**From:** [REDACTED]  
**To:** [Manston Airport](#)  
**Subject:** Manston Airport DCO resident representation TR020002  
**Date:** 25 April 2025 15:08:49

As a resident of one [REDACTED] I've reviewed the available planning documents with interest and have the following comments-

MANSTON AIRPORT DEVELOPMENT CONSENT ORDER
 ACCESS AND RIGHTS OF WAY PLANS SHEET 1 OF 5
 REGULATION 5 (2)(k)
 THANET DISTRICT COUNCIL

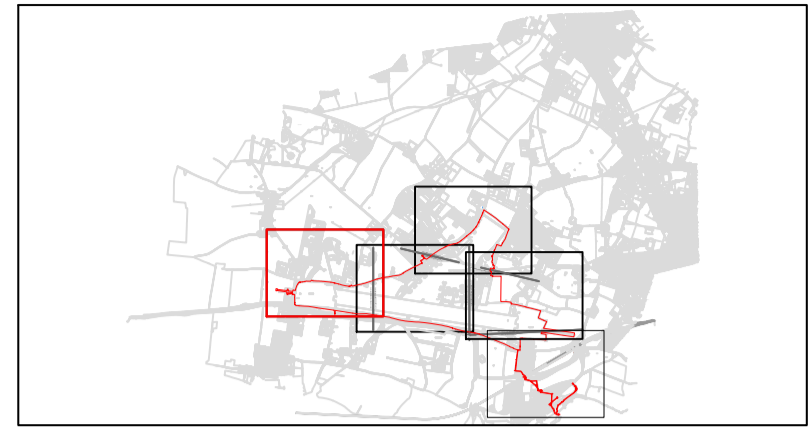
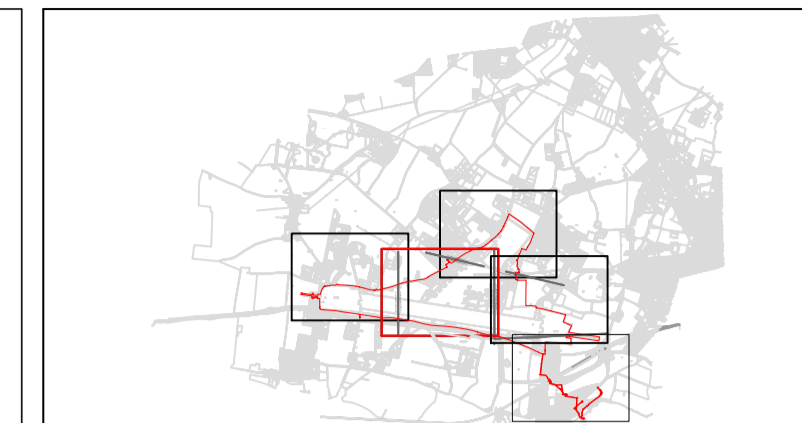
With regard to Spitfire way traffic volume /quantity. Due I expect to recent local developments? Traffic volume has increased markedly over the years that I have been living here, the road is extremely busy now, furthermore, vehicles are traveling at motorway speeds in reality, regardless of the speed limit. Spitfire way - the road in front of my house is the only way to access my property currently, likewise for 7 other households at [REDACTED], whats more, their visitors, the postman, the Ocado man, the Deliveroo man, the bin collection man, bulk waste collection man, Cesspit emptying man, removals van man or woman, all park on the road directly blocking one side of the road at times, there is no other way when they come to the houses etc. When this happens, bad tempered types forced to wait in queue tend to honk their horns or do stupid manoeuvres to get past putting other road users in jeopardy etc. Bin men are particularly vulnerable as they stand in this road facing the fast moving traffic on collection day, I wonder if anyone at the council has risk assessed this situation now that the traffic is so busy and getting busier etc. If it is windy (as it tends to be here) the bins get blown into the road and I've seen near misses as a result - With the planned development at Manston airport I anticipate the traffic volume will inevitably increase such that i think the whole access route to the airport needs a re-think either by adding a spur road for Pouces access from Spitfire much like has been planned for Rose farm or completely reroute this airport access to the Hengist way side of the airport etc.

Spitfire way is used by agricultural vehicles too, we are surrounded by wheatfields and have been for centuries etc. Several sections of the road are too narrow for combinations like a combine and and a HGV traveling the opposite way, when this occurs, since the road is so busy now, traffic quickly backs up and unmanageable gridlock follows, the farmer has needed to go out and Marshall the traffic before on a few occasions etc. Even opposing HGV's sometimes pull their mirrors in to pass each other safely - this is on a 60mph road so the dangers are obvious here etc.

Spitfire way is frequently used by cyclists as well as other traffic, as a cyclist myself it is becoming evident due to the increase in traffic that this is not a healthy mix now. For pretty much the whole length of Spitfire way a HGV cannot maintain the necessary 1.5m (at 30mph i might add) separation distance when passing and therefore has to trundle behind per the rules etc.
